RE: SITE PLAN – ADMINISTRATIVE DEVELOPMENT FACILITATION TEAM
PR-2024-010691, SP-2025-00031
7520 RAINBOW BLVD NW; LT 11-A BLK 2 PLAT OF LTS 10-A, 11-A, 19-A THRU 22-A BLK
2UNIT 14 VOLCANO CLIFFS SUBD CONT 2.0312 AC

Please see responses to DFT comments for **PR-2024-010691**, **SP-2025-00031**. Also included are the updated construction drawings to address the comments.

2
A201
EXTERIOR ELEVATION & PROFILE PLAN - WEST
SCALE: 1" = 10'-0"

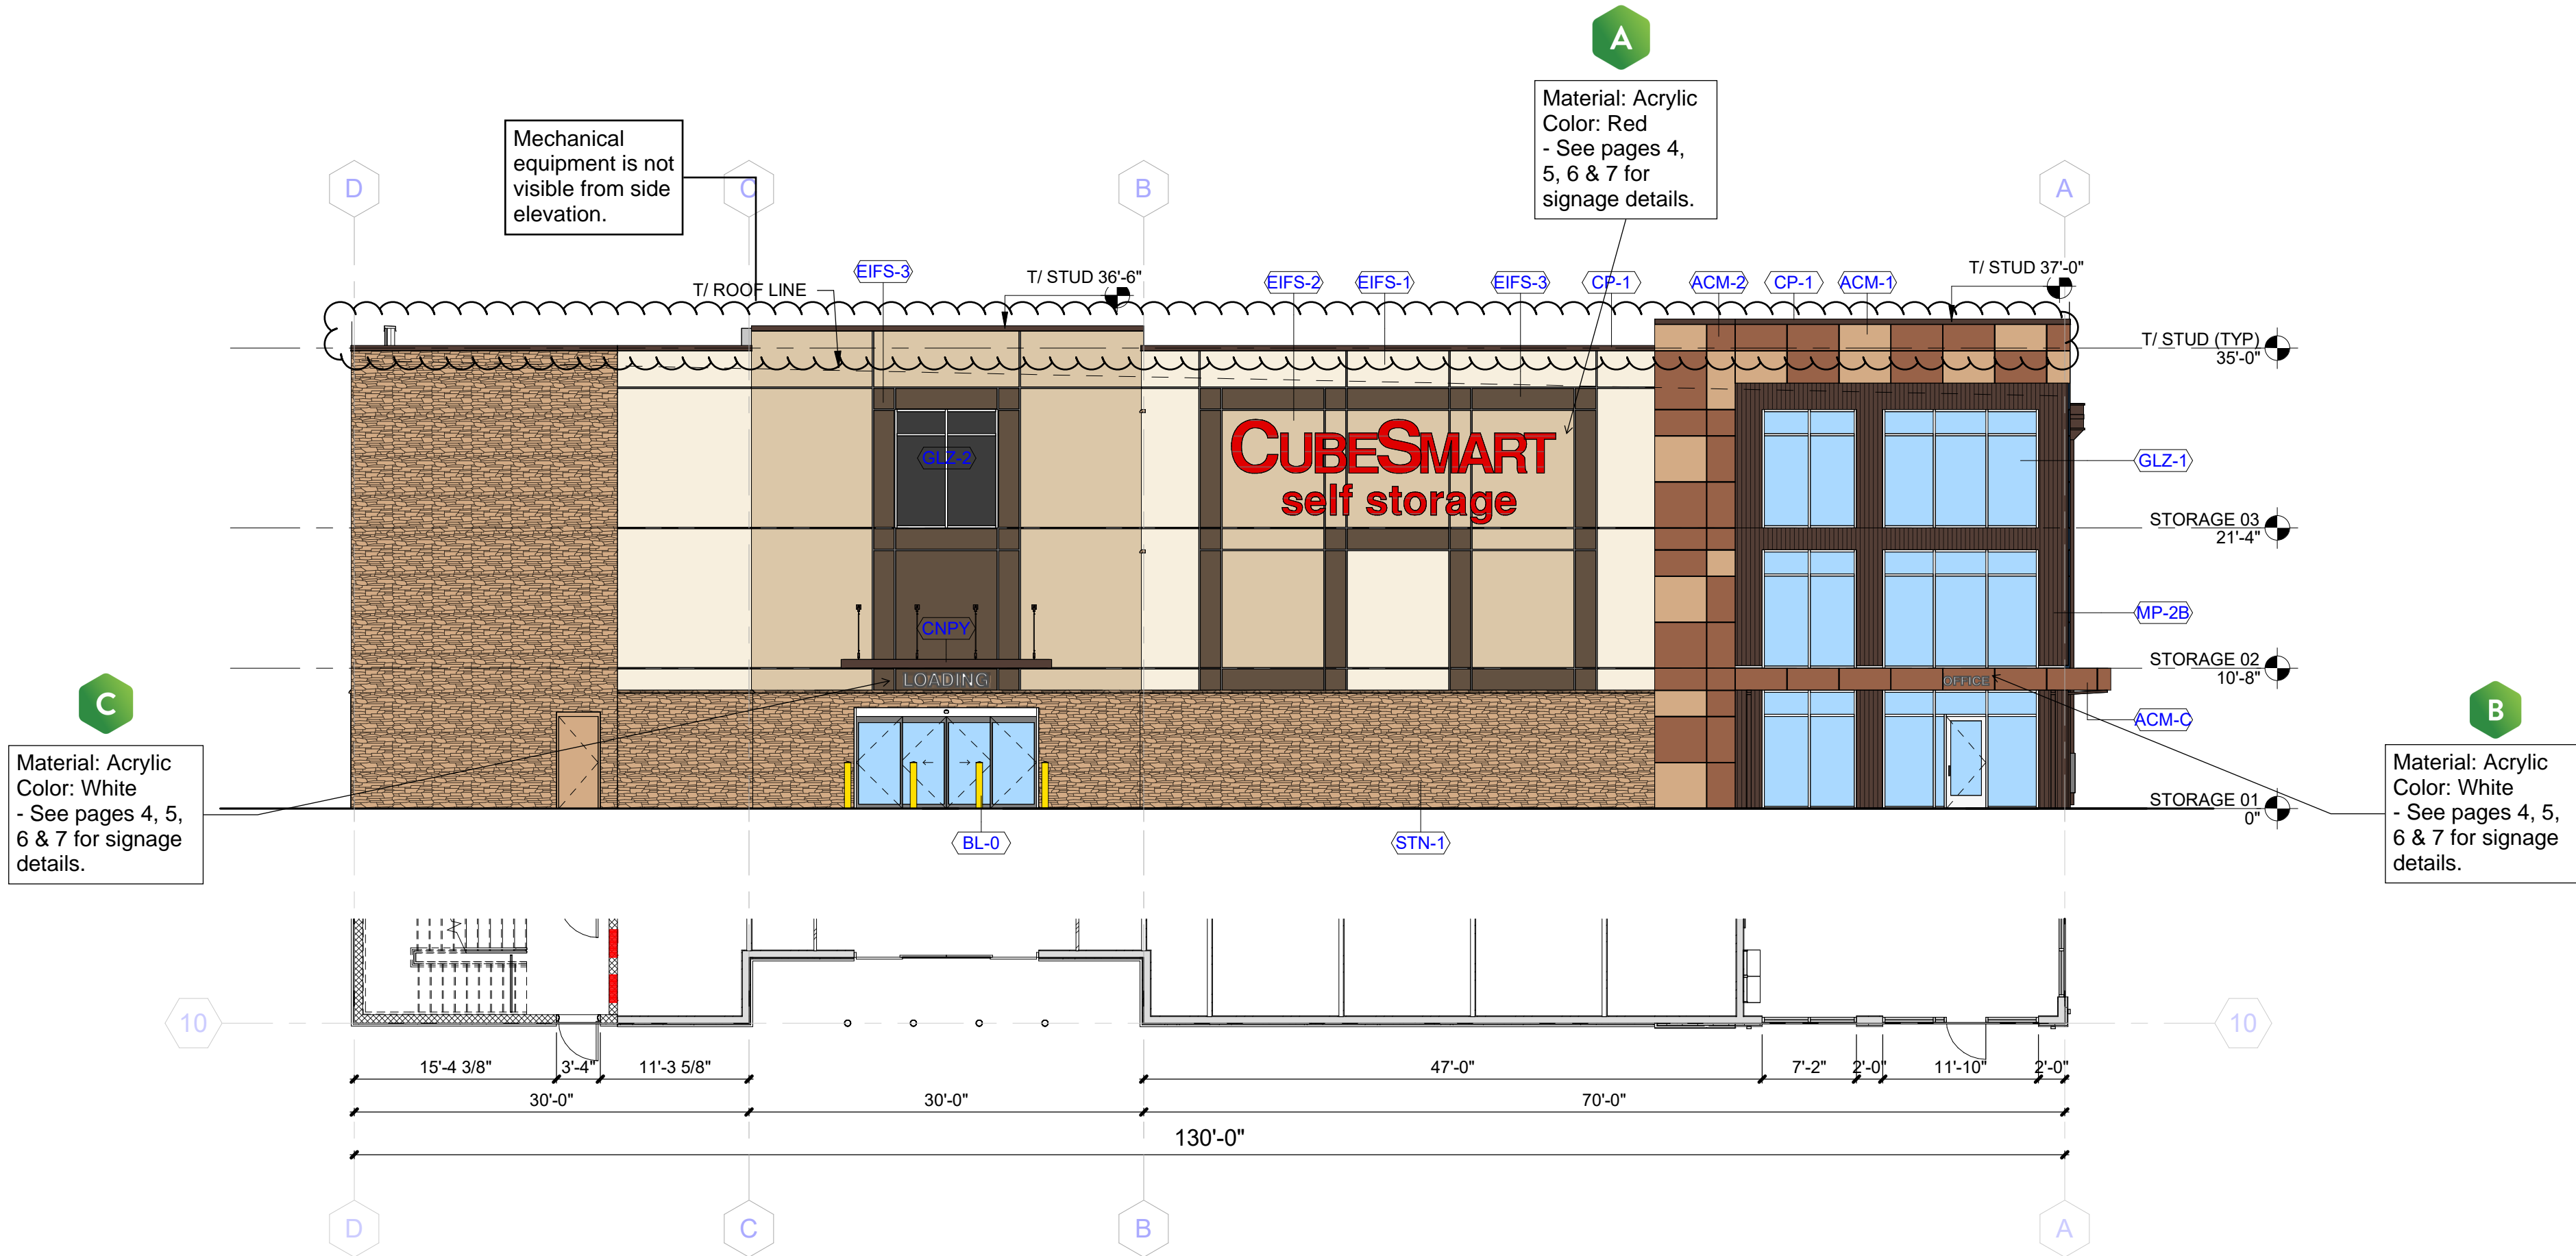
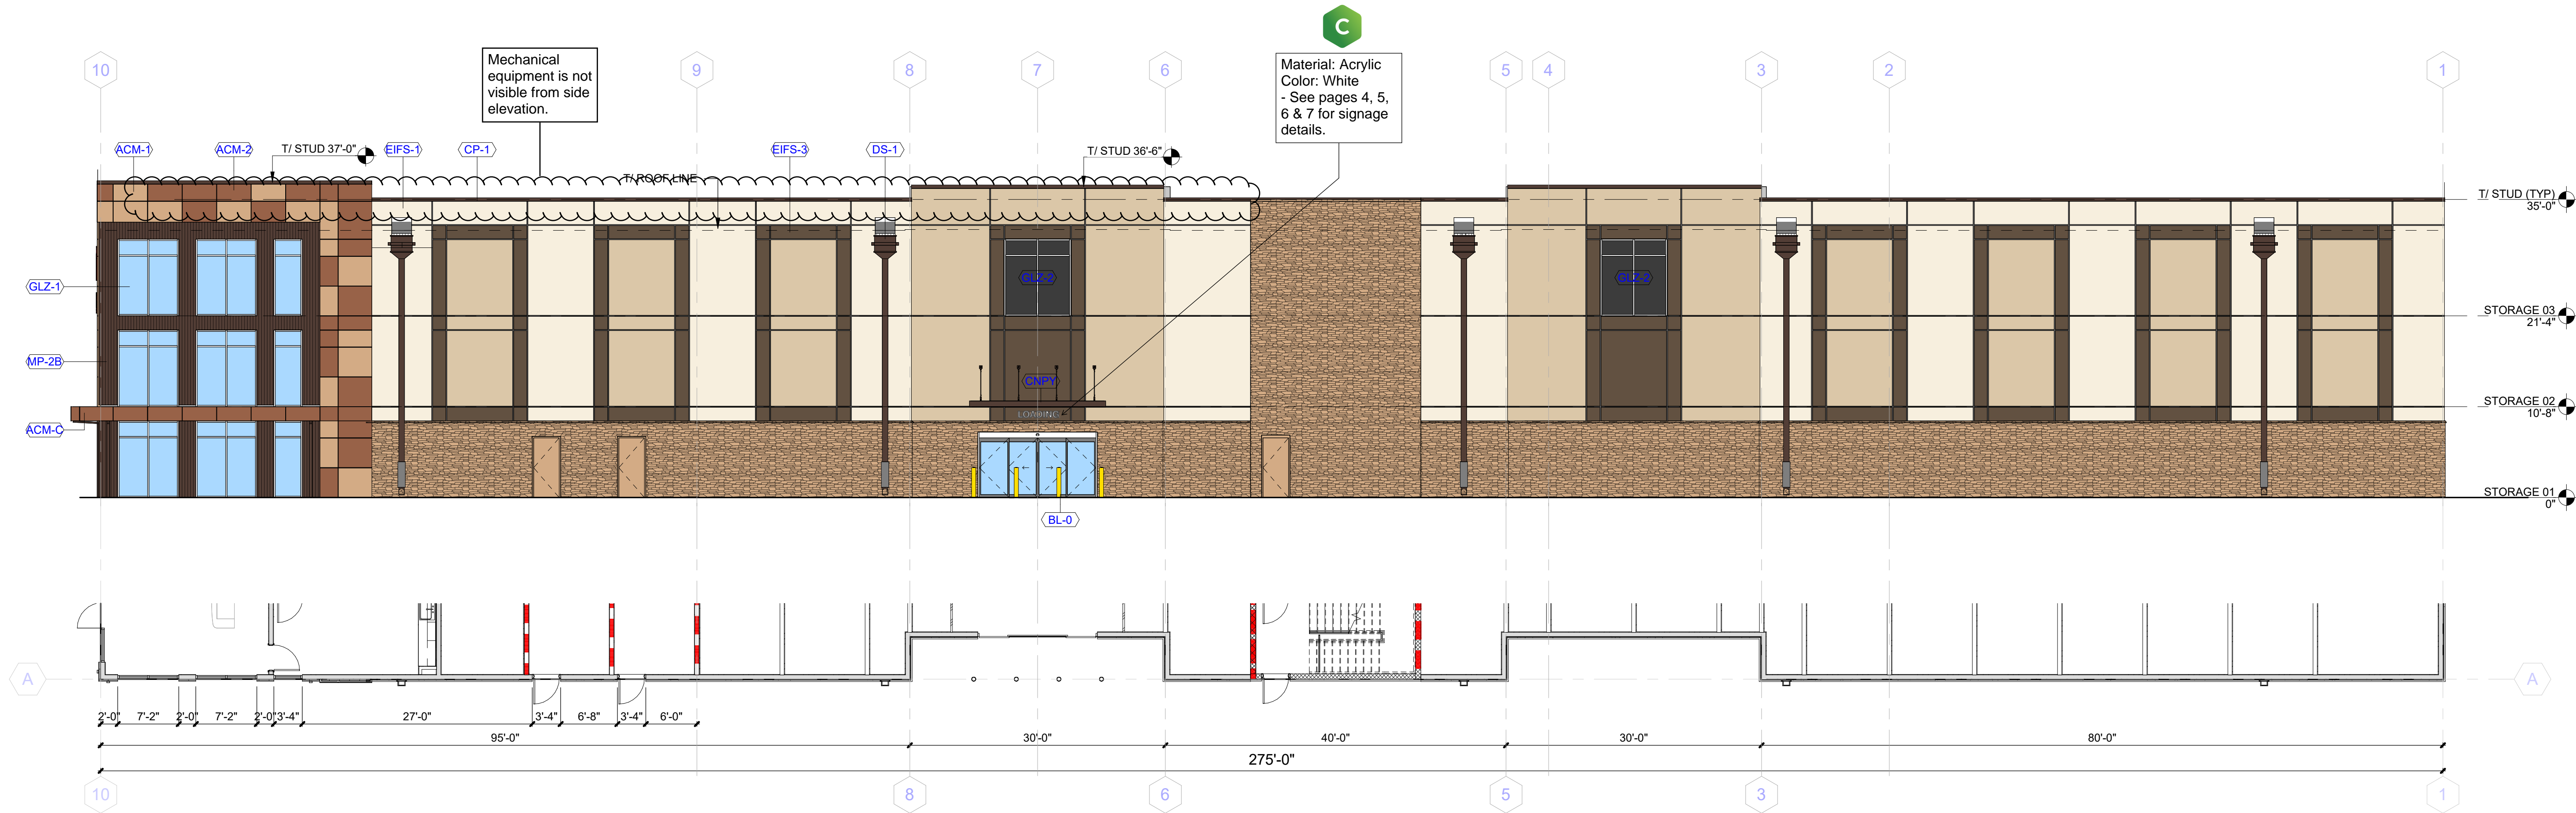
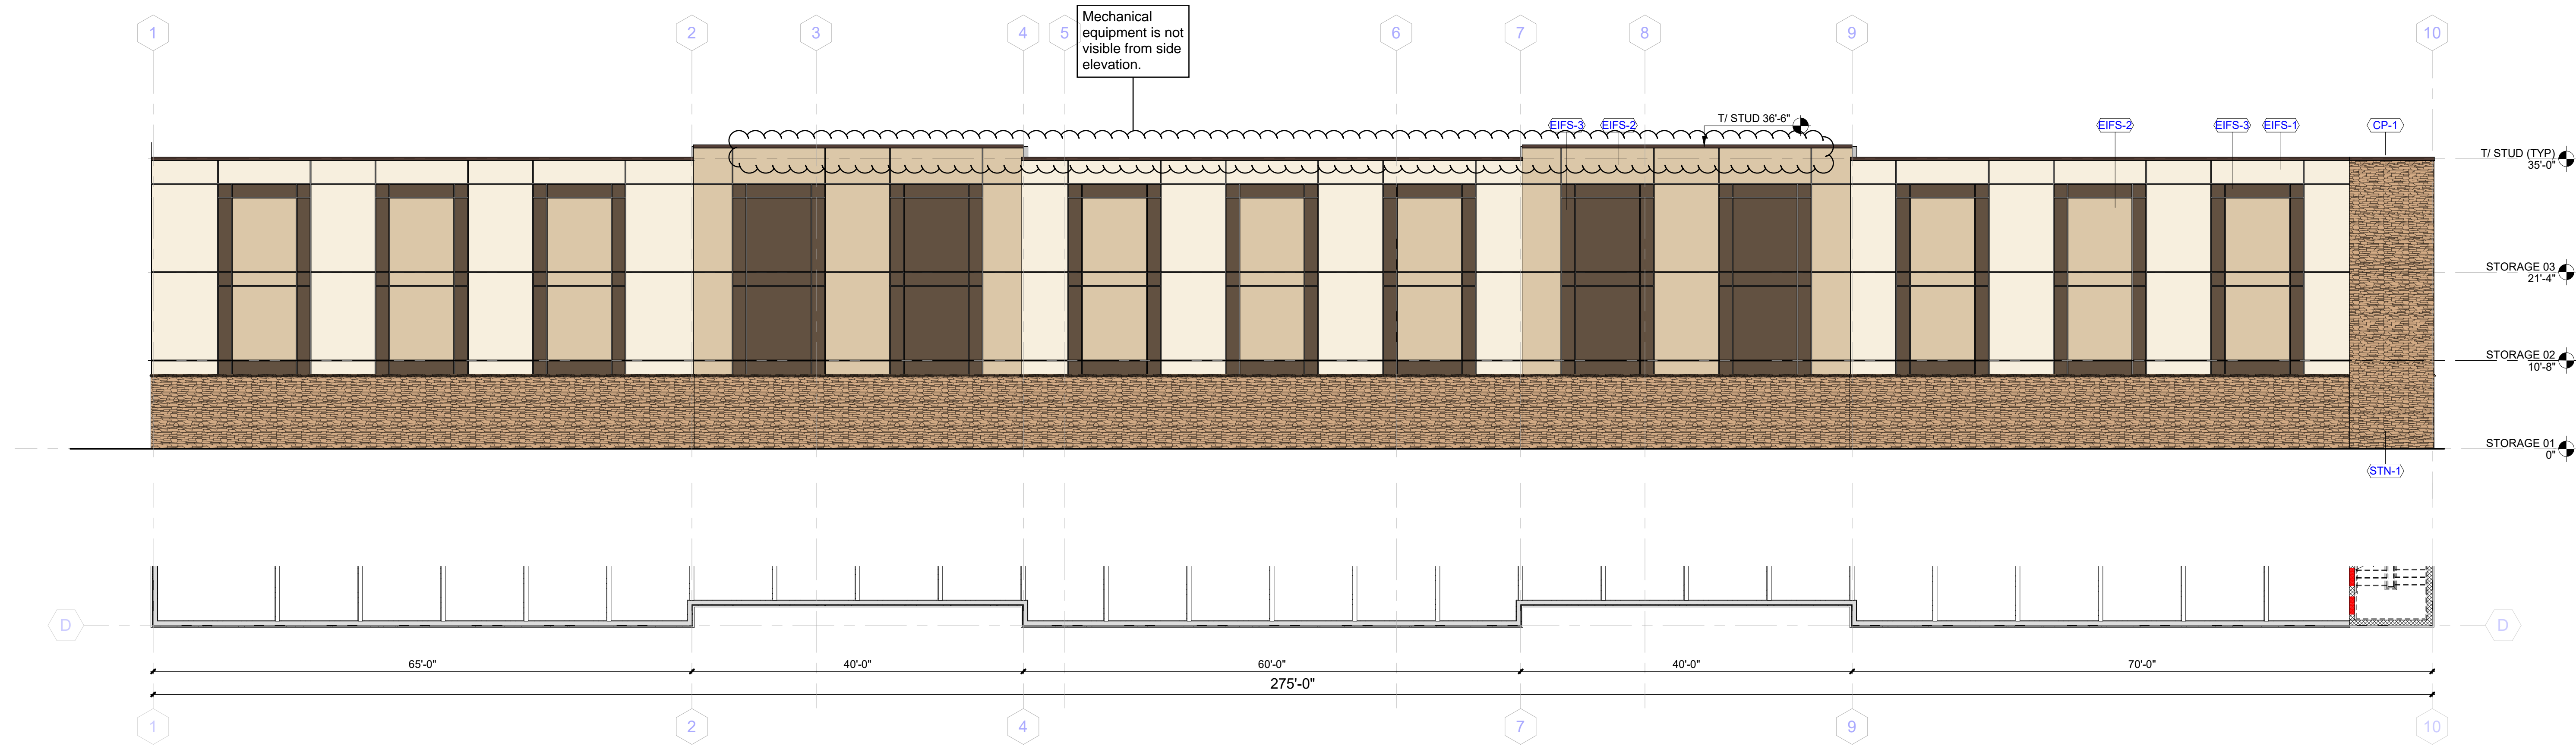
- 1. Lighting: Must add location of light fixtures on elevations and notes indicating the compliance in the Elevation Plans, or provide separate Lighting details sheet for those purposes.
 - a. Provide sheet giving lighting types and details, showing how lighting complies with Sections 4-3-D-29 and 5-8 of the IDO (as in response to prior Planning comments).
 - b. Must show how meeting requirements for Light Trespass, as per IDO 5-8(F)(4).

RESPONSE: Building Exterior Elevation sheets have been updated to identify the lighting plan.

- RESPONSE: Building Exterior Elevation sheets have been updated to identify the proposed lighting.
- 4. Confirm whether the trees shown in the landscaping plan were recommended by the City Forester.
